City of Albuquerque Stormwater Construction Site Inspection Report

Project Name:	Storm Cloud Estates				
Location:	Tierra Pintada				
Site Contact Name & Agency	Kevin Griffin	ESC File No.	H09D022B		
	DR Horton	NPDES Id. No.	NMR10012Y		
Inspection Date:	10/23/19	Start/End Time:	0855/0915hrs		
CoA Stormwater Inspector:	Timothy E. Sims				
Construction Phase:	home construction				
Type of Inspection:	☒ Regular	☐ Storm Event	☐ Post Storm Event >0.25"	☐ 311/Complaint	☐ Follow Up

### Concrete Washout Area

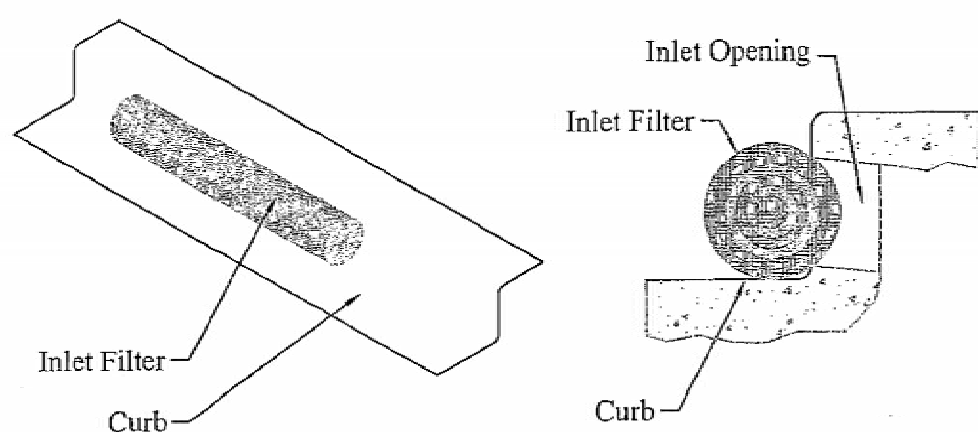
Item Number	Deficiency/ Corrective Action		
1	8608 Down Burst drywall mud washout in front yard.		
2.1	Discharge off site? (Y/N)	No	
4	Self Inspection Reports		Latest report Date: 10/21/2019
